DATE: October 6, 2014  
TO: Jack Cloud, DRB Chair  
FROM: Catalina Lehner, Senior Planner *CL*  
RE: Project #1010180, PNM La Morada Substation  
Site Development Plan for Building Permit

On September 11, 2014, the EPC voted to approve a site development plan for building permit for an approx. 3.2 acre site located on Vista Oriente Rd. NW, east of Unser Blvd. NW and north of Ladera Dr. NW.

Staff reviewed the September 30, 2014 version of the site development plan for building permit and notes the following, minor issues:

<b>PNM</b> PUBLIC SERVICE COMPANY OF NEW MEXICO		
SITE PLAN DETAILS		V.3
PNM - LA MORADA SUBSTATION		
DR: JLB	TR: OK:	DATE: SEP 30, 2014
CKD: TMF	APP: ACAD FILE:	SCALE: N.T.S.
REV. NO.	USS-19202	SHEET 2 OF 6

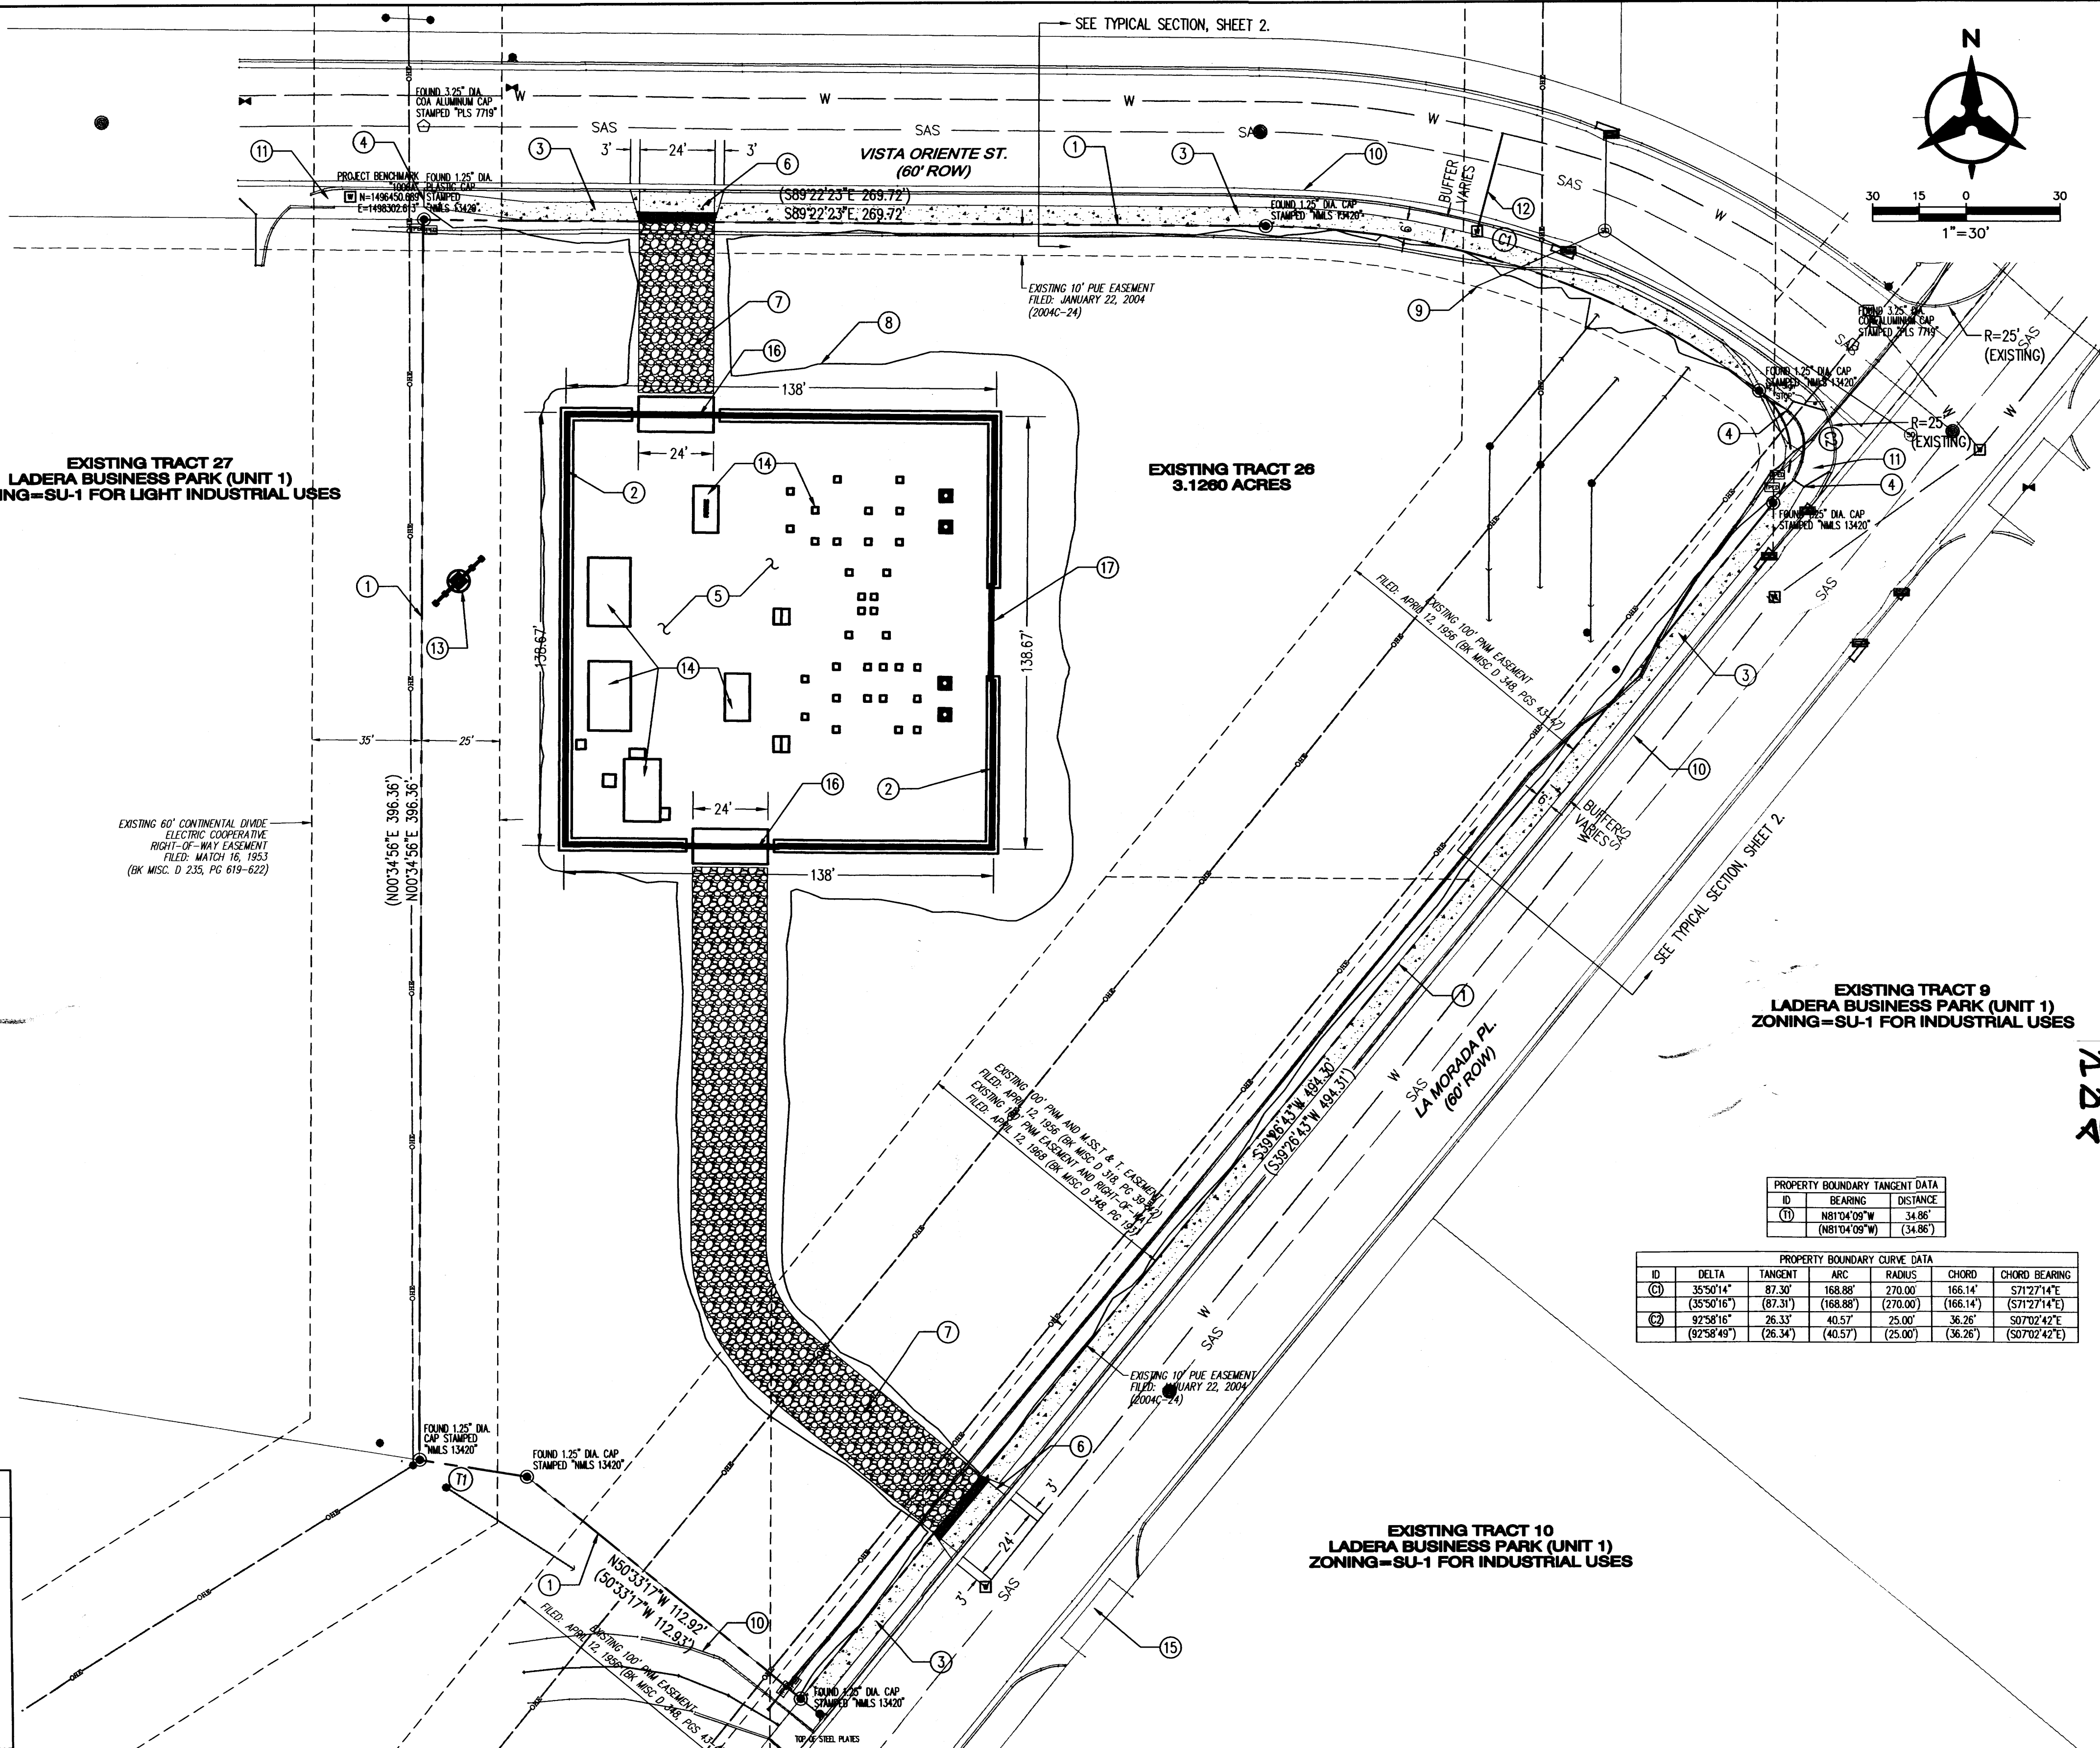
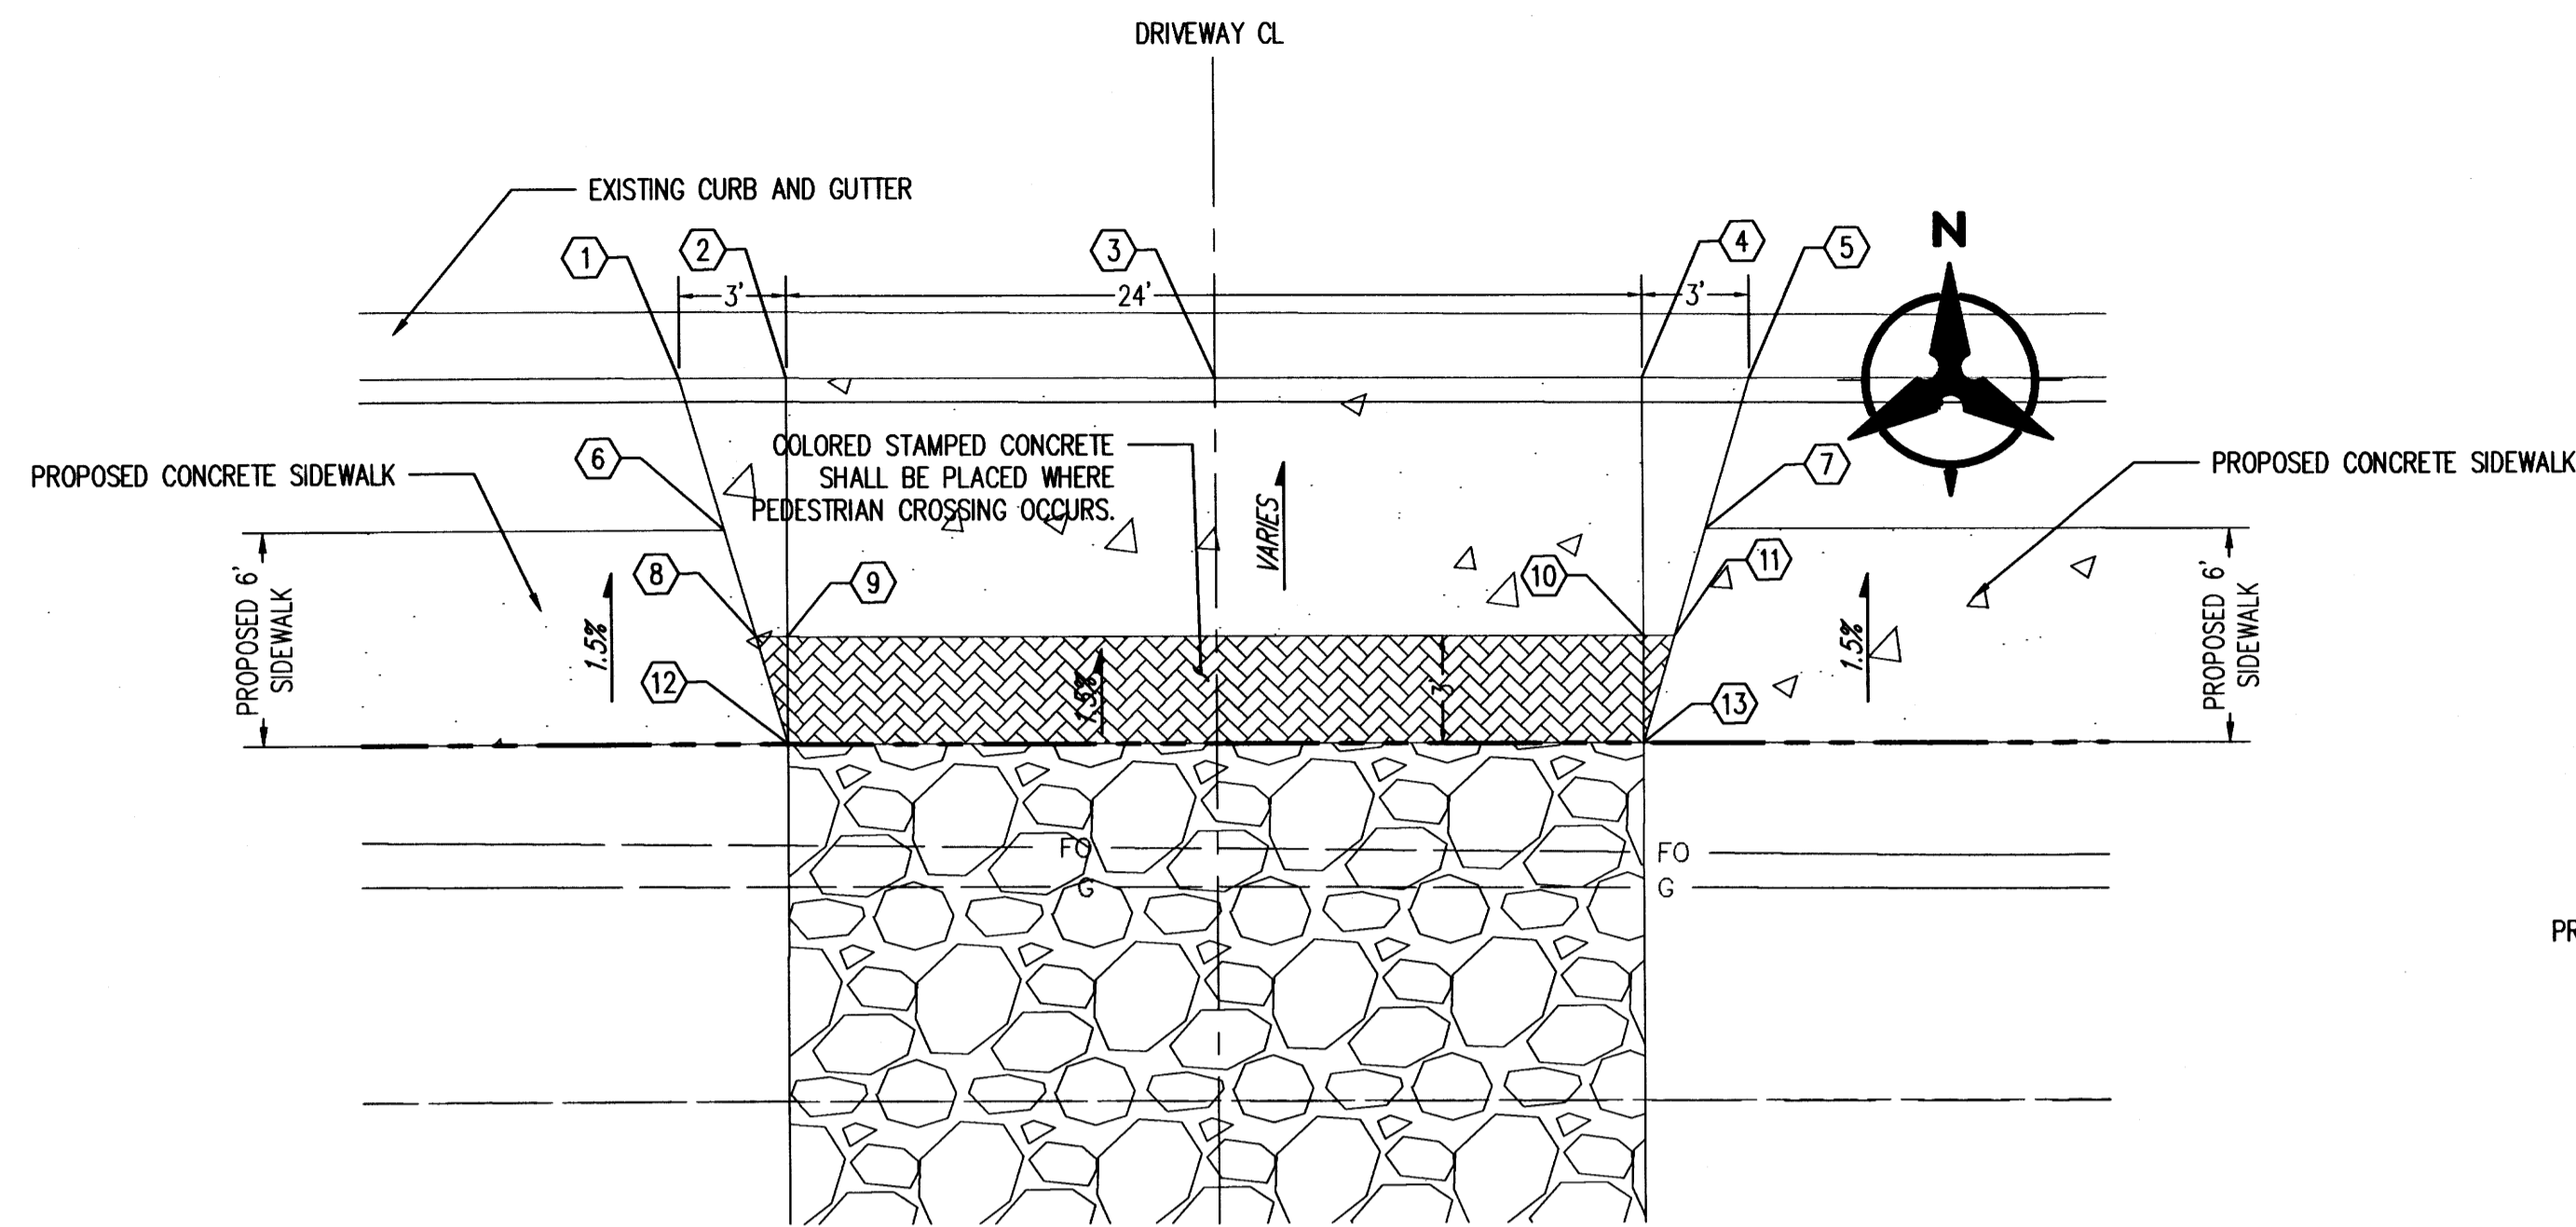
Condition 7C: Add a different symbol for the textured, colored concrete as is crosses drive-aisles. It should not look the same as the symbol for plain sidewalk.
